# Bramford to Twinstead Reinforcement

Document 8.3.2.2: Applicant's Written Summary of Oral  
Representations to Issue Specific Hearing 1

Final Issue A  
September 2023

STOUR VALLEY EAST  
 CABLE SEALING END  
 COMPOUND AT LITTLE  
 CORNARD

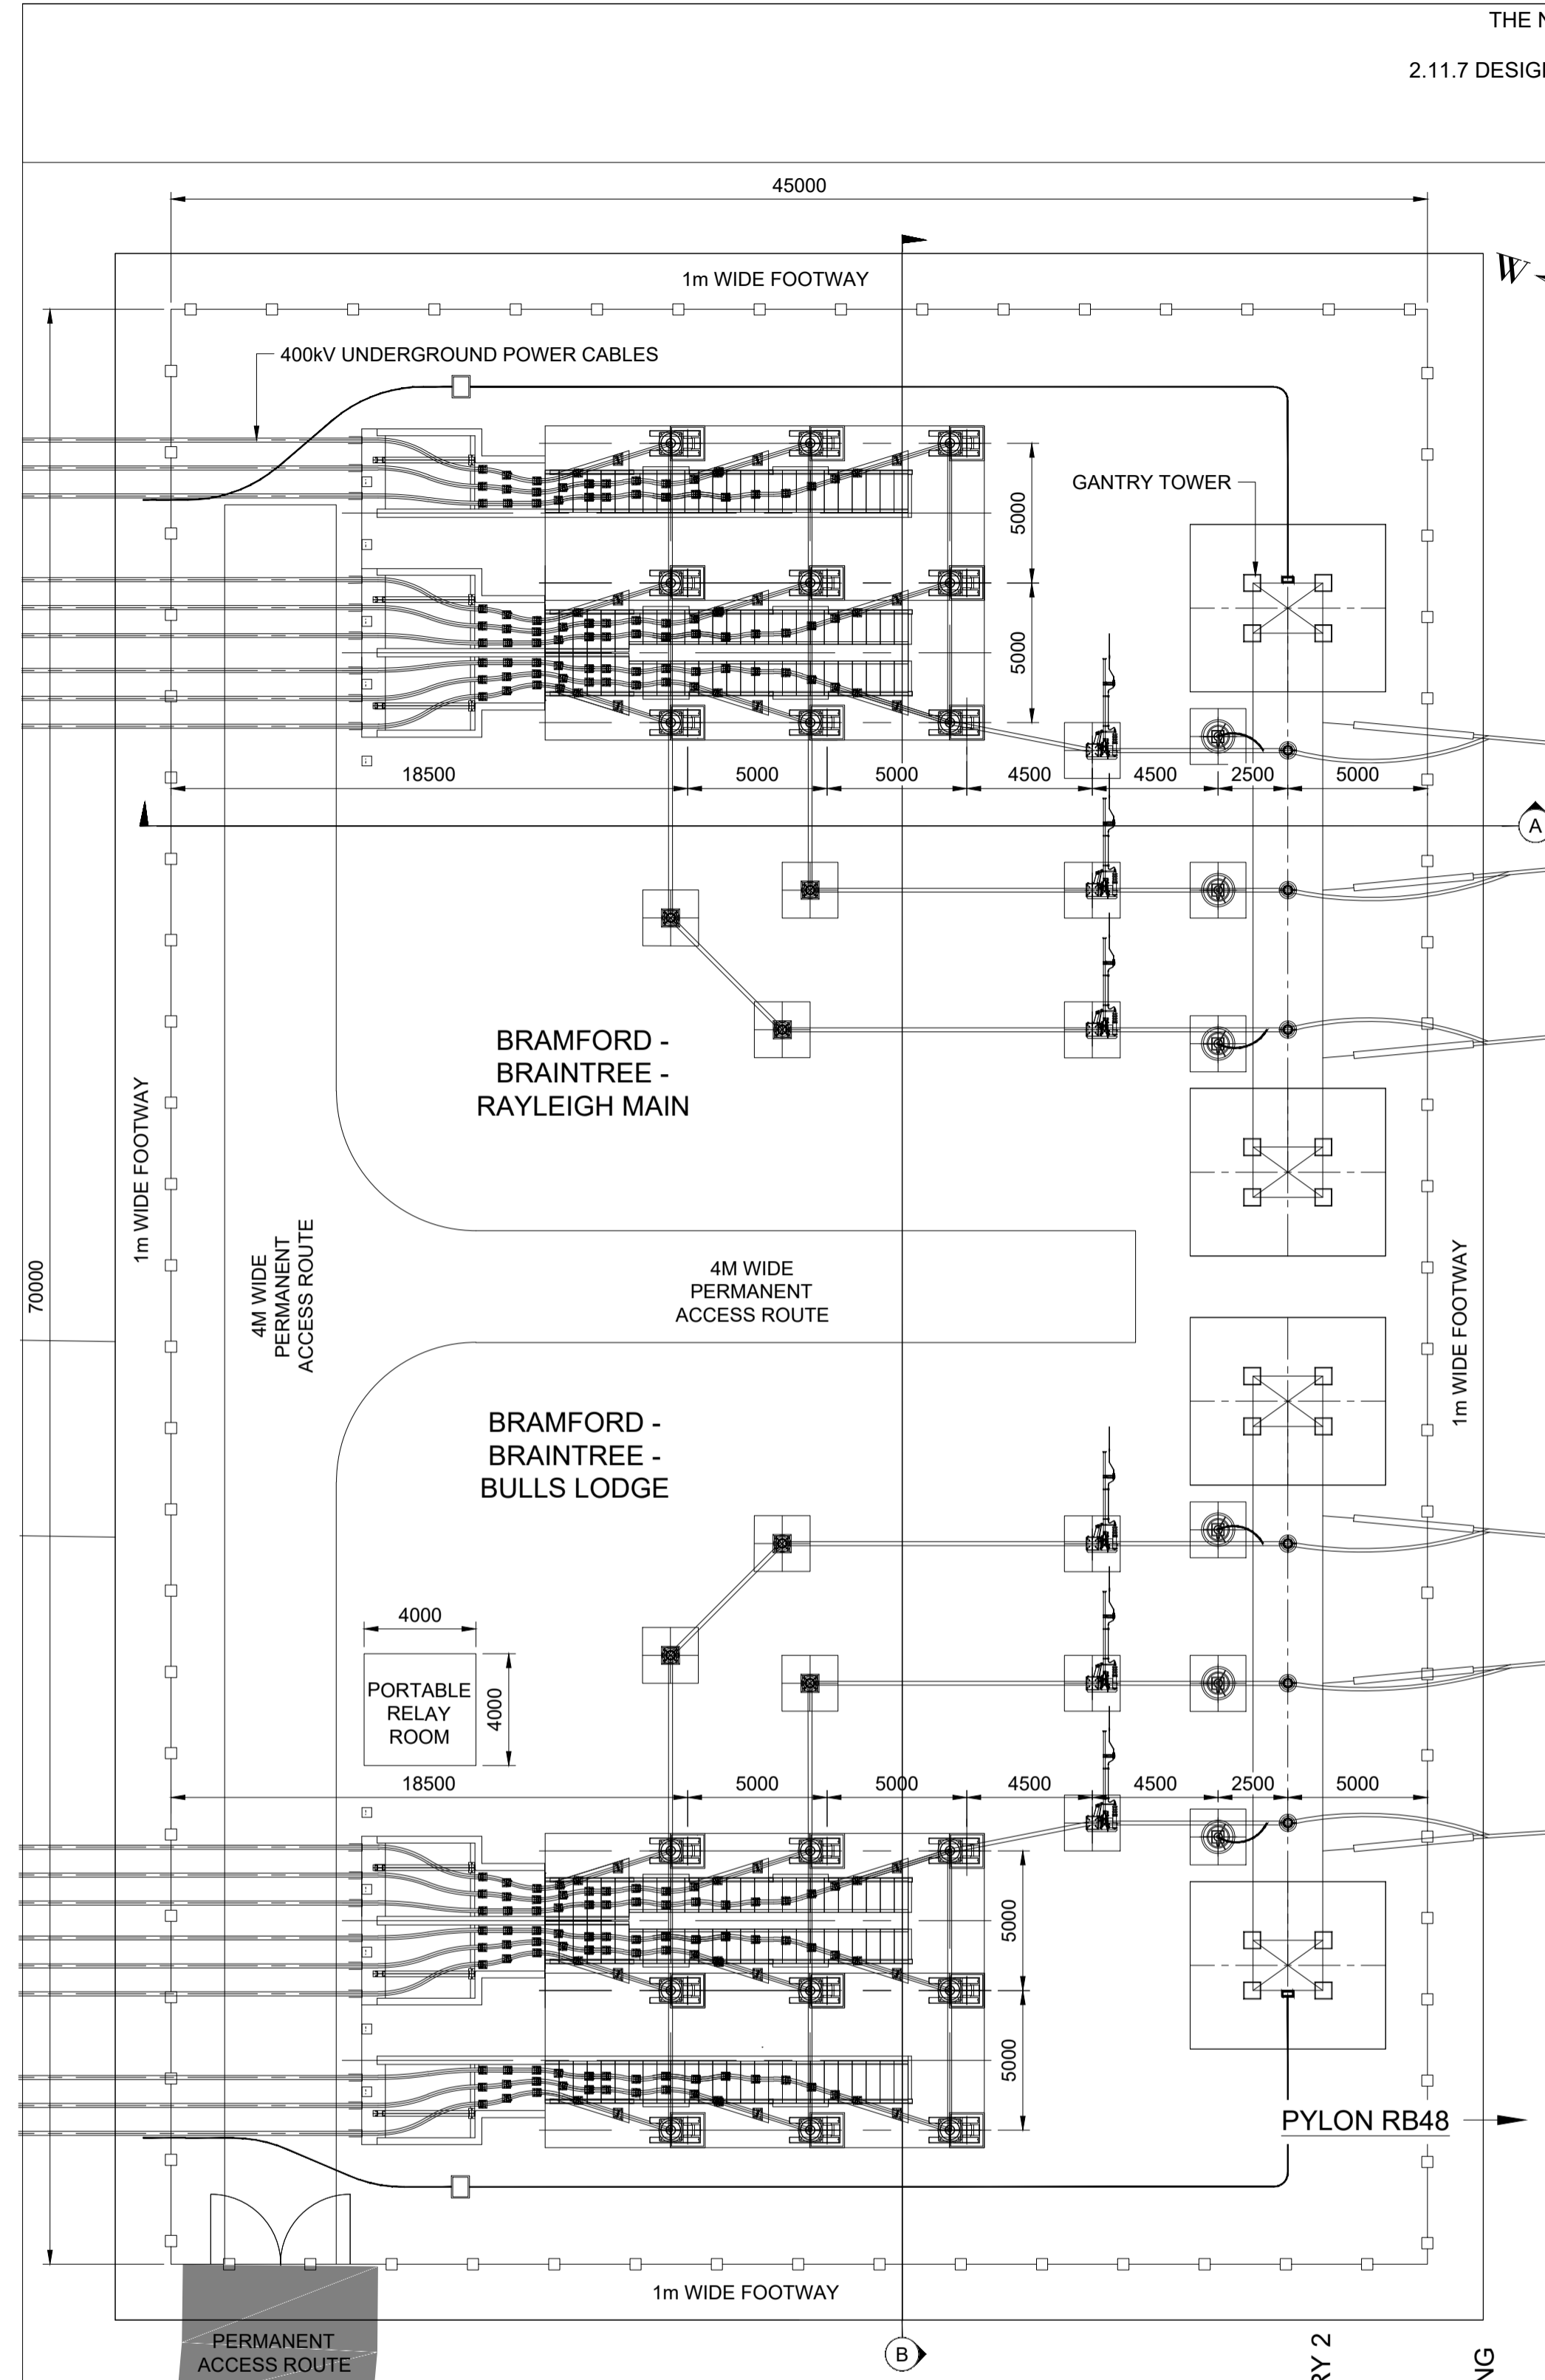
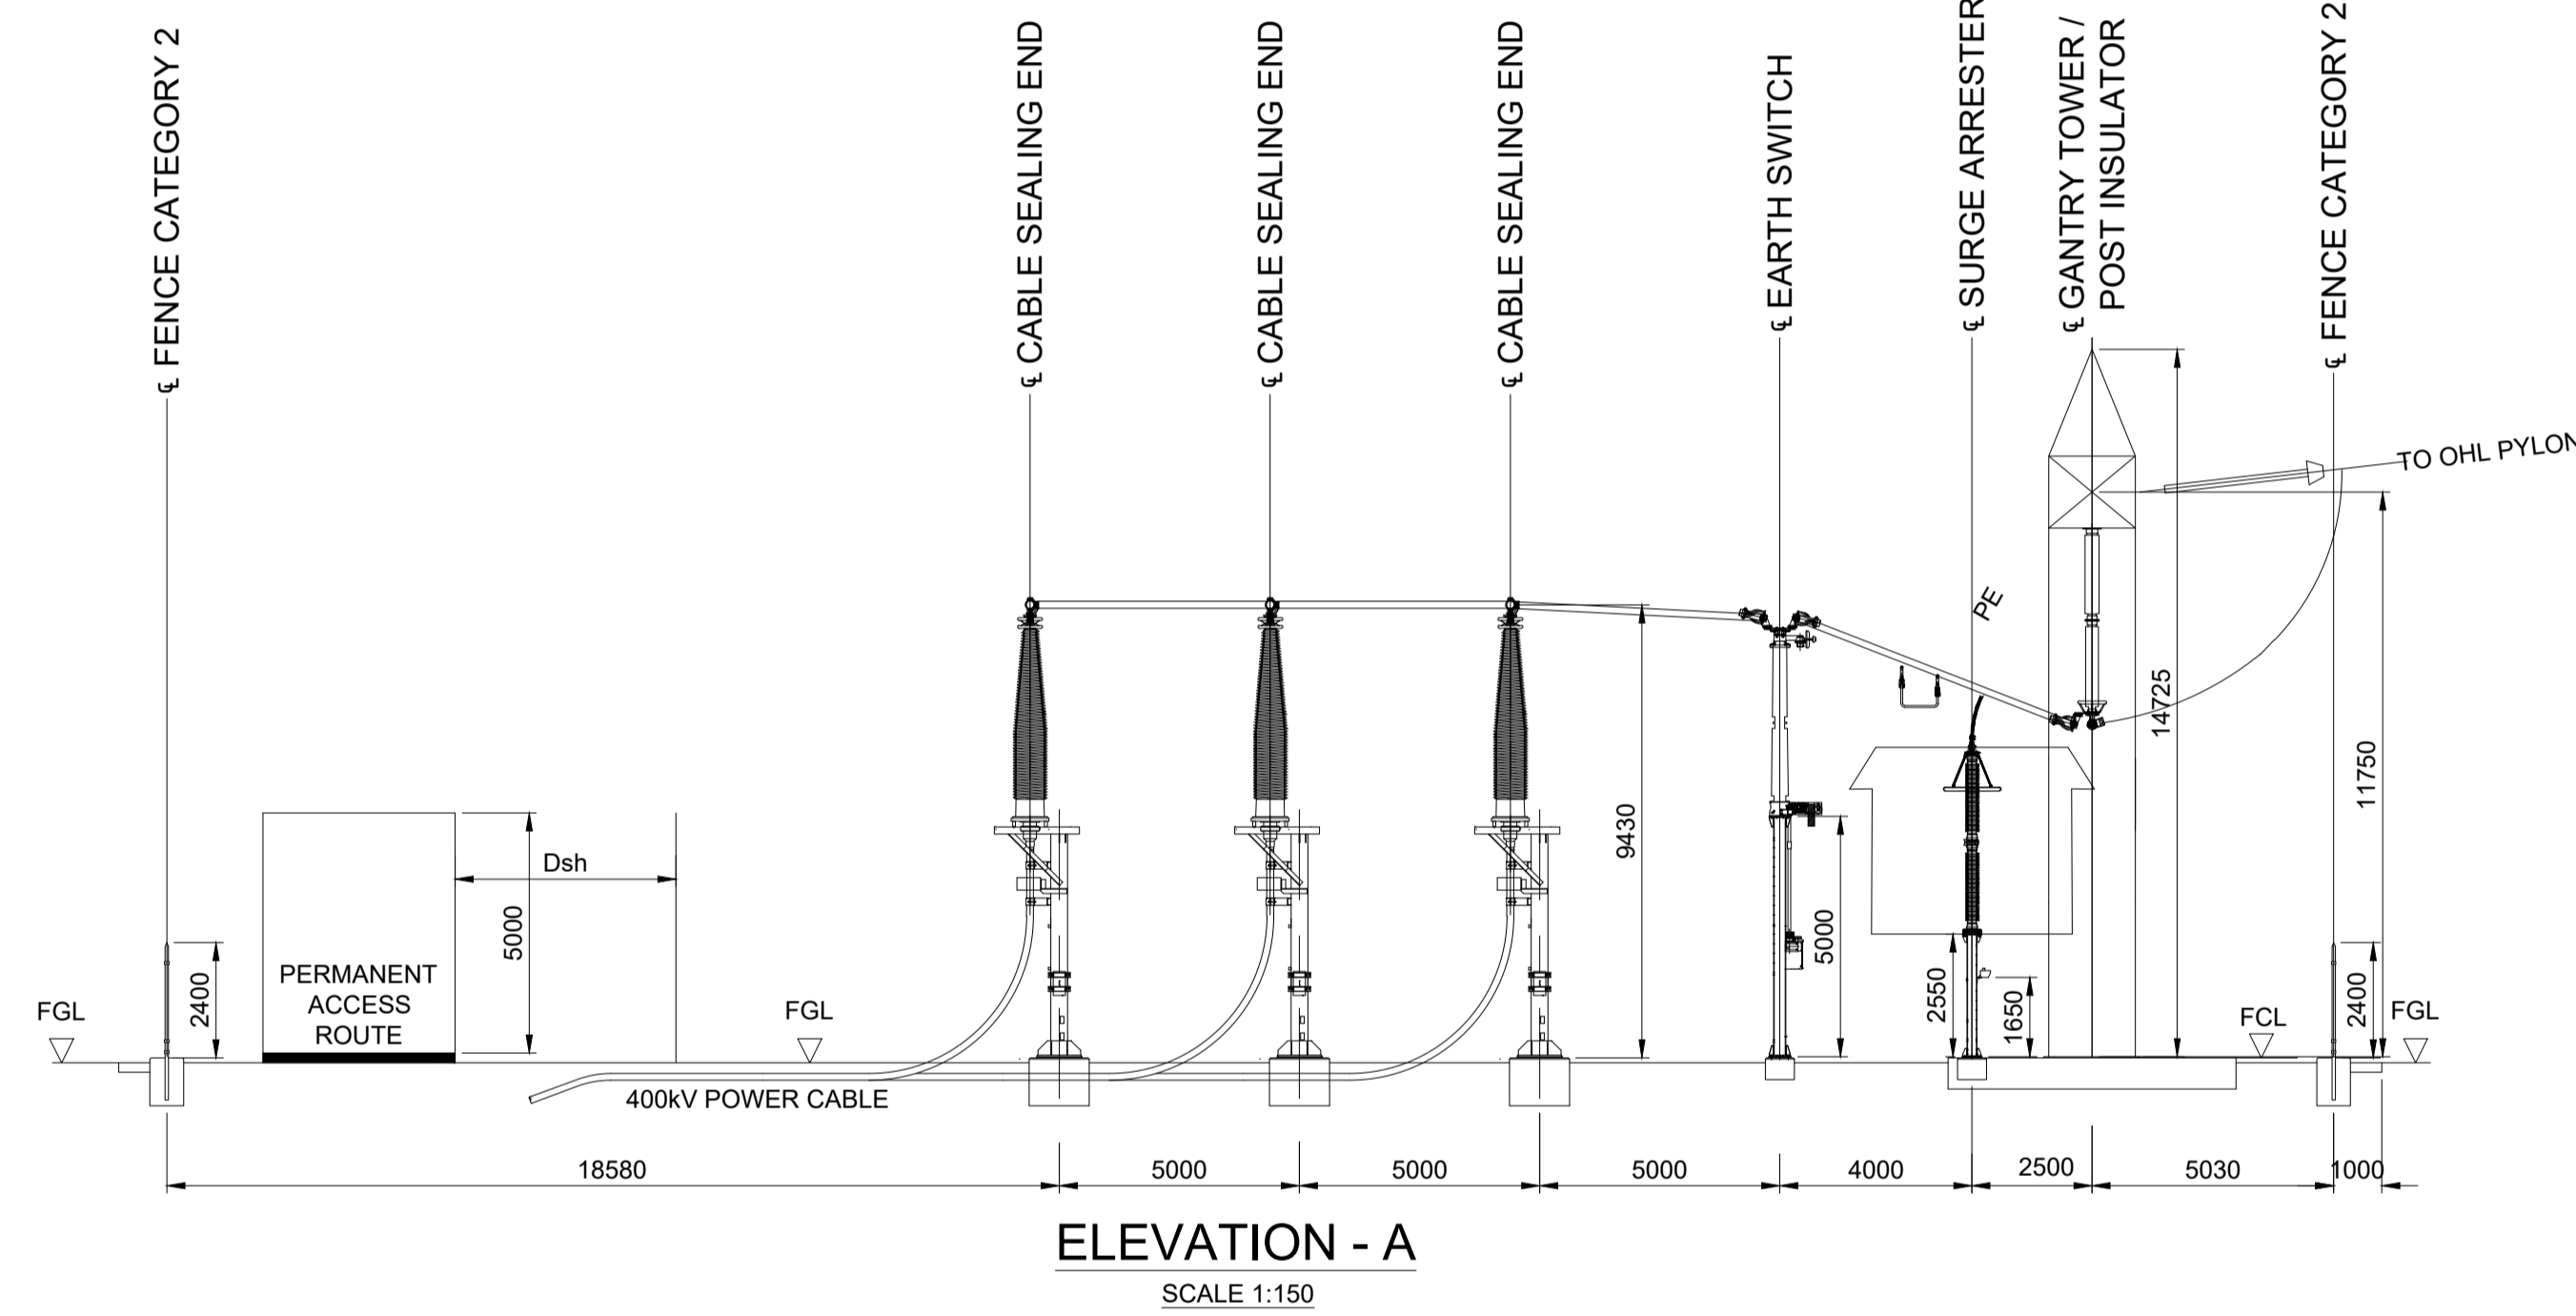
#### **Stour Valley East CSE Compound**

The equipment used within the CSE compound, as per Design and Layout Plans Stour Valley East Cable Sealing End Compound [APP-025], is in accordance with technical requirements and with other similar compounds utilised throughout the National Grid network. The size of the compound is circa 45m x 70m and is necessary to accommodate the required equipment and to provide a safe and secure compound throughout the asset life.

The LoD for the CSE compound are intended to allow the main works contractor, once appointed, some flexibility with the final positioning / layout of this compound. This assists with the detailed design of the compound and the interface positions between the underground cable and overhead line whilst at the same time constraining the position of the CSE compound within the area assessed.

The LoD have been derived by applying a 25m buffer zone on each side of the CSE compound dimensions, as per Design and Layout Plans Stour Valley East Cable Sealing End Compound [APP-025] which allows for the repositioning of the compound to suit final overhead line / underground cable alignments, or to relocate equipment items if needed to avoid unexpected ground conditions.

At the CSE Compounds the non-linear LoD and the linear LoD overlap to allow for all equipment to be accommodated within the LoD.
